Subject: RE: Y/43/21/DOC - Land East North End Rd/West of Church Lane - AMENDS REQUIRED

Condition 7 – surface water drainage Drainage Engineers comments

NEW ACCESS ROAD & PARKING PERMEABLE
PAVING CONSTRUCTION
TYPICAL SECTION DETAIL

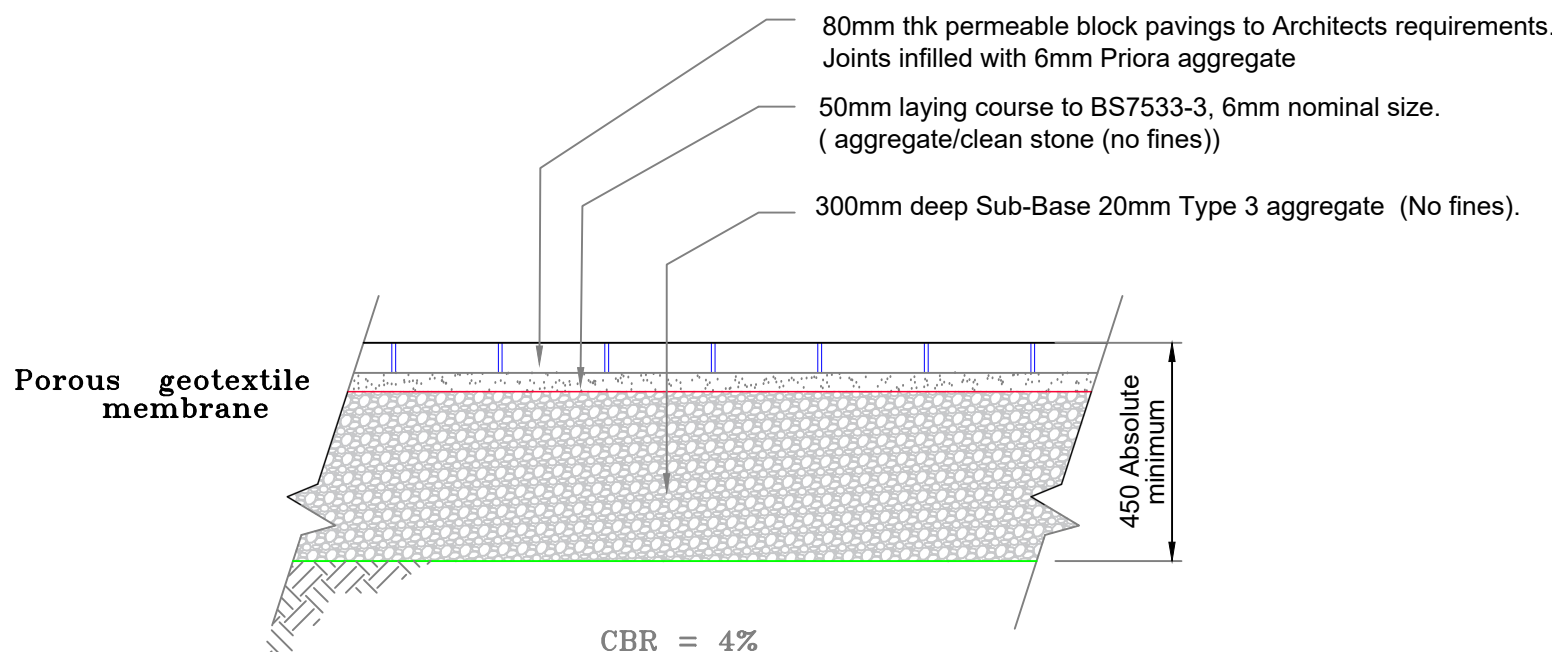
7. Please provide 1 in 10 year plus cc water levels and ensure that incoming invert levels to soakaways are above this level. **TO FOLLOW** *Awaited.*
8. Construction detail drawings of permeable paving need to detail geotextiles. **SEE UPDATED DRAWING** *Okay, thank you.*

9. Please provide a construction detail drawing of the proposed baffles in the permeable paving. **SEE UPDATED DRAWING** *This detail drawing appears to show a pipe at the base of the baffle, the pipe has no dimensions or details specified. However, its location at the base is likely to effectively make the baffle pointless. Please reconsider.*

TYPICAL SECTION
THROUGH
SOAKAWAY

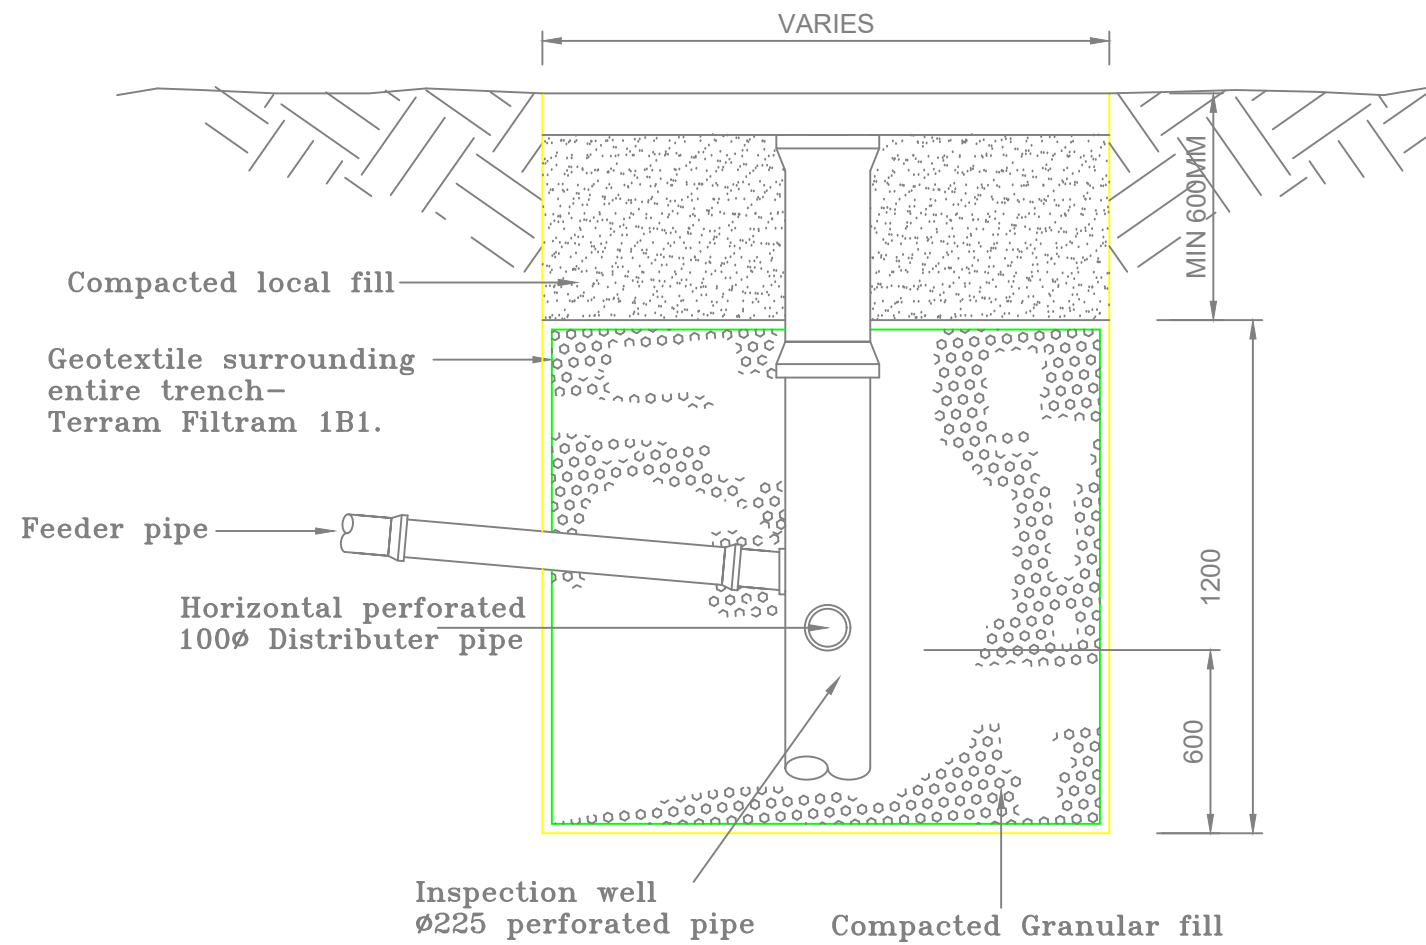
6. Please clearly label proposed soakaway dimensions on plan, i.e. invert level, depth, length, width, depth of cover above soakaway. It does not appear that calculated soakaway dimensions can be provided. **SEE UPDATED DRAWING** *This has not all been provided. Plans are still missing details on base of soakaway levels, and do not clearly provide details of depth of soakaways and available cover above soakaways.*
